**Consultation Response from KC,
Highways Development Management**

2023/92754 The Four Sons Inn, 129, Clough Lane, Rastrick, Huddersfield, HD6 3QJ

Variation condition 2 (plans) on previous permission 2021/94264 for erection of porch and external decking

Date Responded: 18/10/2023.

Plan
1:100

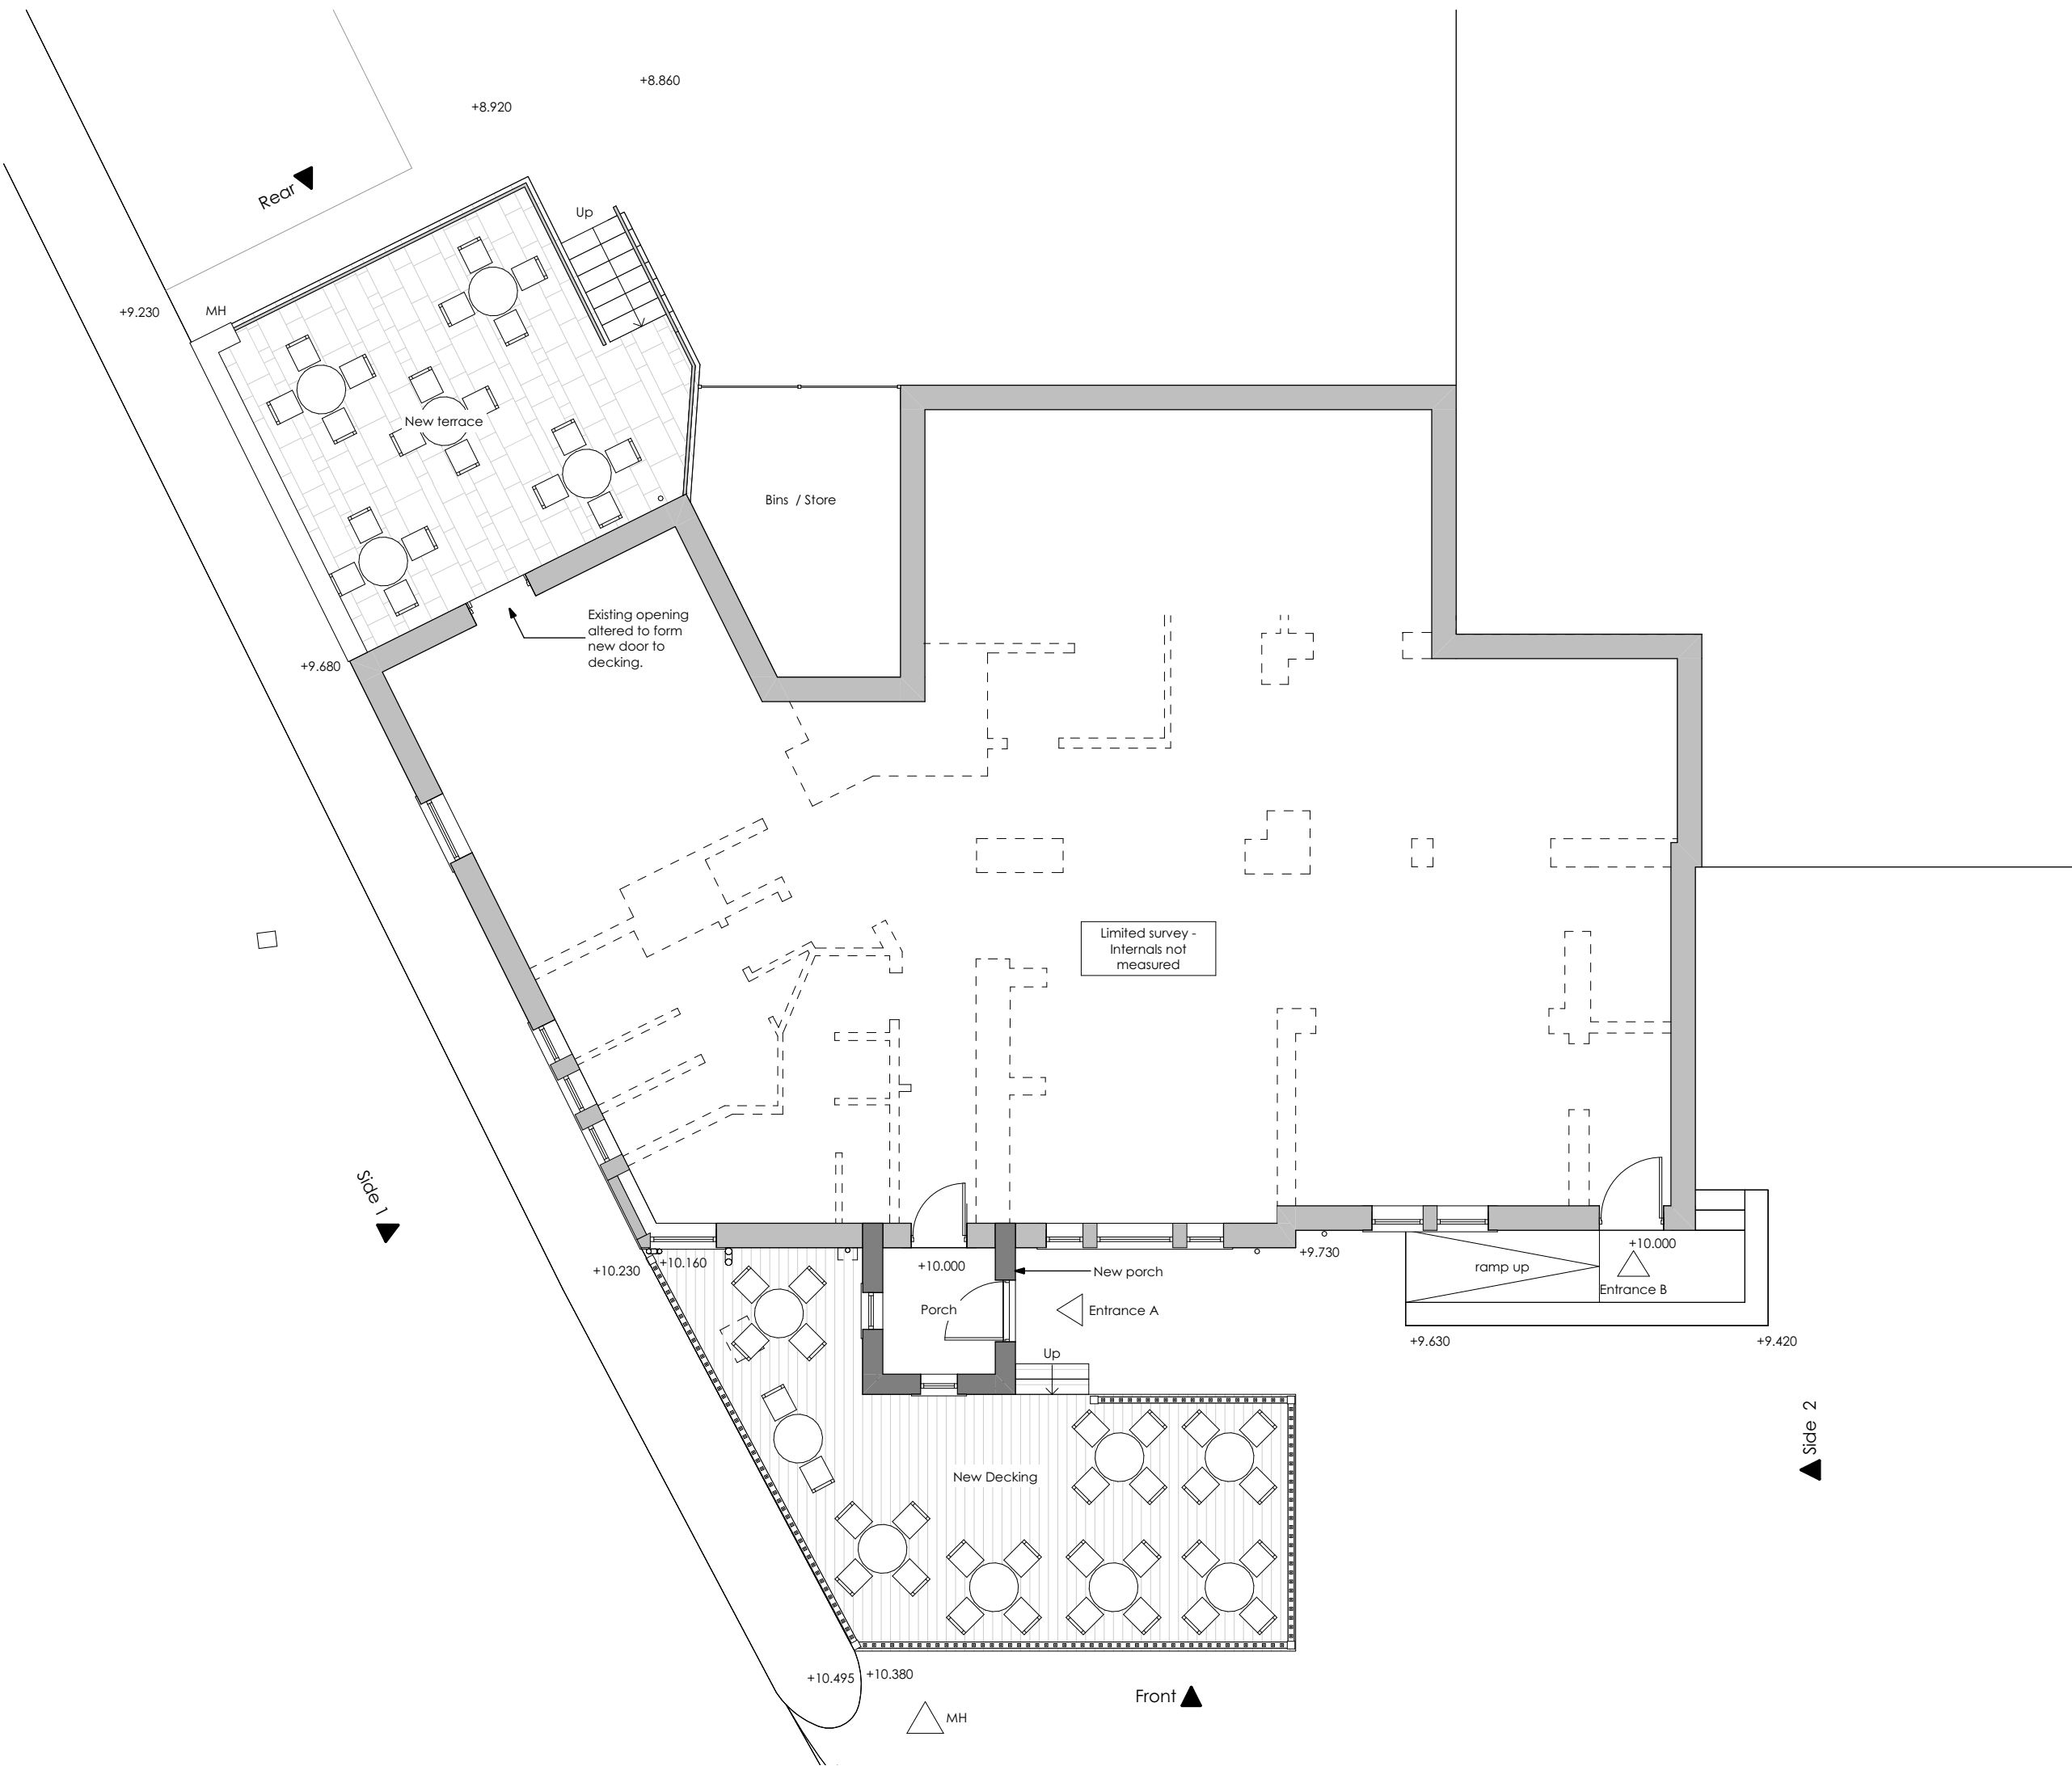
Some of the decking will be erected over 3 parking spaces to the west side of the building. This loss of 3 parking spaces is not considered to have a detrimental impact as 28 parking spaces are being retained which is adequate and this is also supported with good transport links with a bus stop directly outside the site.

The proposed location of the proposed deckings will not encroach into the existing vehicular accesses therefore retaining them.

Bin storage will remain located within the car park and the waste collection arrangements will also remain as existing.

Highways Development Management consider the loss of 3 parking spaces to be insufficient to create a significant impact, so we offer no objections to the application and therefore the proposals are acceptable.
